Lr.No.C4/179/90

Dated: 3.9.'90.

Sub: MMDA - Planning Permission - Proposed  
Construction of Poor Boys Study Halls  
and Workers Quarters building in S.No.  
596 of Peenamallee village - Remittance  
of Development Charge - Requested - Reg.

SITE PLAN SCALE 1:2000

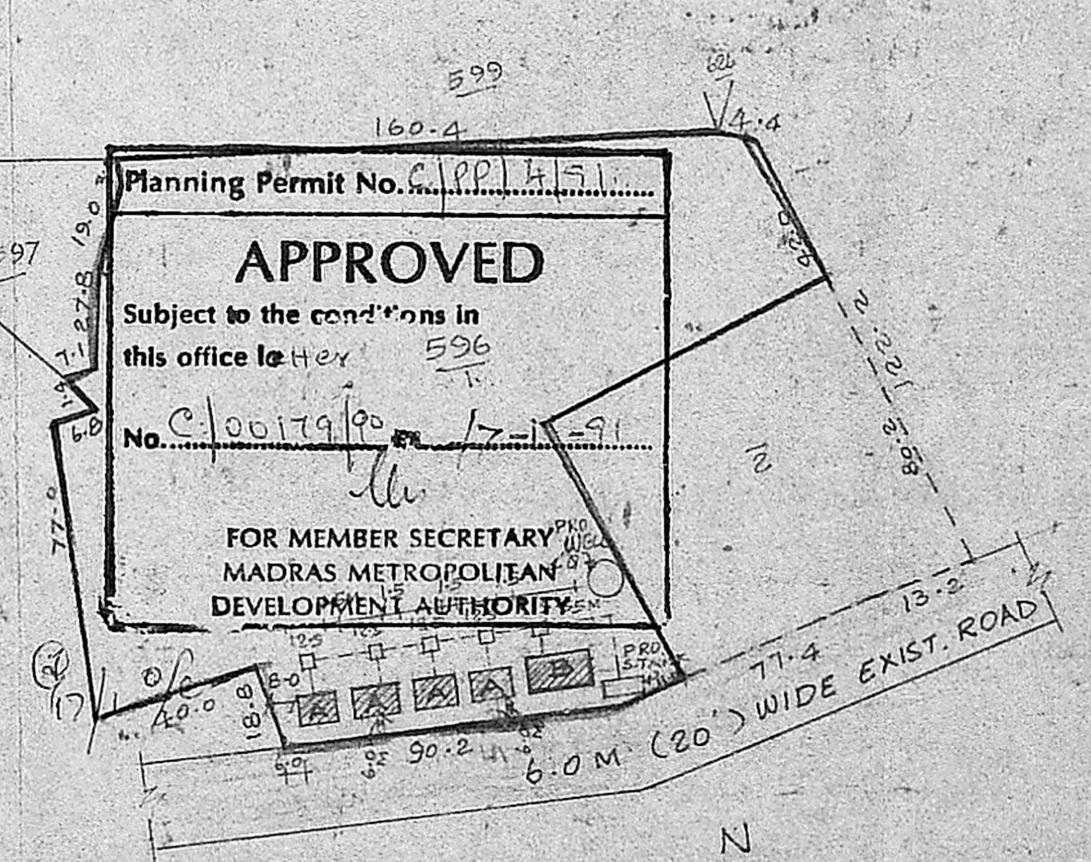
2. In this connection, you are requested to remit a sum of Rs. 11,100+350/- (Rupees Eleven thousand four hundred and fifty only) towards Development Charges for land and building and Rs. 50/- (Rupees Fifty only) towards the Scrutiny Charges by a Demand Drafts of any nationalised Bank in Madras, drawn in favour of the Member-Secretary, MMDA and the same may be remitted at the cash counter of the MMDA within ten days on receipt of this letter. You are also requested to furnish an undertaking deed duly notarised and Revised plan showing the S.No. as 596 instead of 595/1 and the proposal buildings insite plan to be drawn to the Scale.
